**SYDNEY OLYMPIC PARK AUTHORITY
DESIGN REVIEW PANEL
ADVICE SHEET**

Project	3.1 – Site 53, New Residential Development
Presentation / Review Date	22 September 2016
Panel Present	Peter Mould (A/Chair) Bill Tsakalos Caroline Pidcock Prof Linda Corkery Prof Peter Webber
COI Declaration	None. It was noted that Caroline Pidcock and Peter Poulet had participated in the Design Competition Jury.
Also Present	Ben Woods, Darlene van der Breggen, David Martin - SOPA
Presenters	Phillip Rossington – (BVN) Mark Gazy – (BVN) Graham Cooper (Mirvac) Amar Prashant (Mirvac) Alex Black (Mirvac)
Documents made available	Power Point Presentation and A4 handout
Inherited decisions	The SOPA Board has instructed that development should comply with the height restrictions in the Draft Master Plan 2030 (2016 Review) and that no special exceptions be made for site 53.
Previous relevant SOPA Advice	DRP meetings at 19 March and 20 August 2015, 17 March 2016
General Observations/ Overall Comment	The proposal is an amendment to the existing approved design incorporating increases in maximum FSR and building height proposed in the DRAFT MP2030 (2016 Review). The revised design also addressed a number of design iss

21 JUNE @ 1500

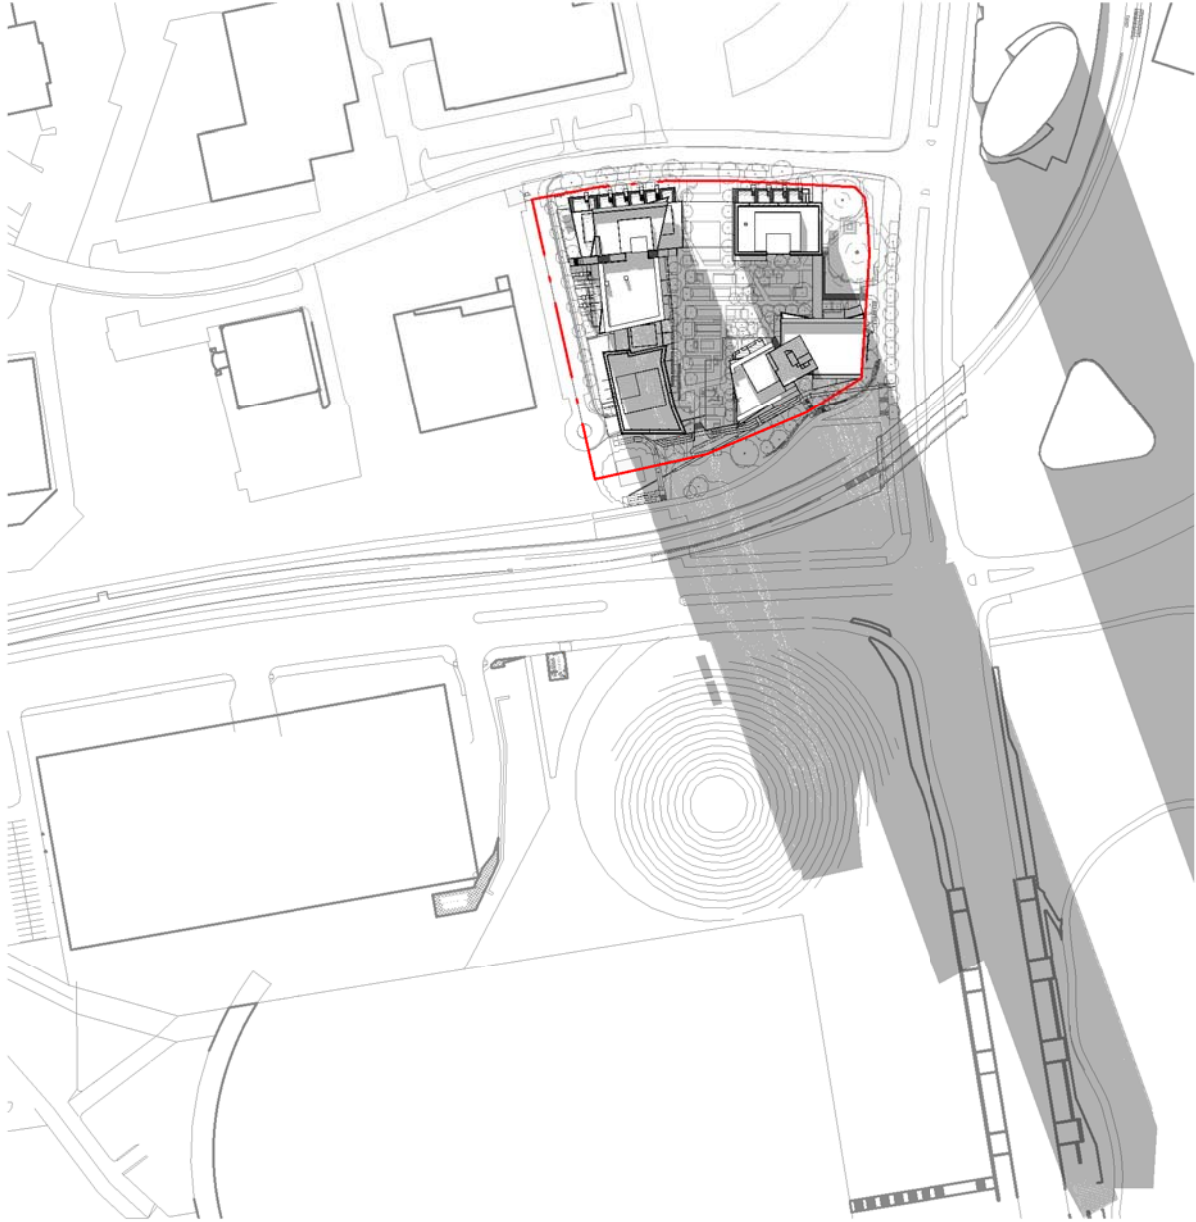
MATERIALITY AND BUILDING EXPRESSION • There is little to differentiate / modulate the ground and lower levels against the tower levels. • Further reduction in the extent of brickwork has resulted in glazing being the dominant architectural language. • the use of brickwork at the plinth only, with minor insertions in the upper levels of the podium, has Is not substantial enough to be meaningful. LANDSCAPE AND PUBLIC ACCESS • The potential for a public through site link continues to be overlooked, especially as this could offset the impact of the substantial density uplift though it is acknowledged this is not a requirement in the Master Plan. • Programming of communal facilities does not seem adequate for the needs of 700 households, eg play area is very small, only one communal area. • The path connections into and through the linear park are too indirect, eg walkway around the transplanted fig tree at the end of New street. BUILDING SETTING • There was little detailed information on the resolution and integration of setbacks and edges along all three street frontages and the linear park. OTHER • Large number of units accessed from each lift core will discourage neighbourly / community interaction. • The percentage of units achieving 2 hours of sunshine on June 21 has decreased, while the number achieving flow through ventilation was uncertain.
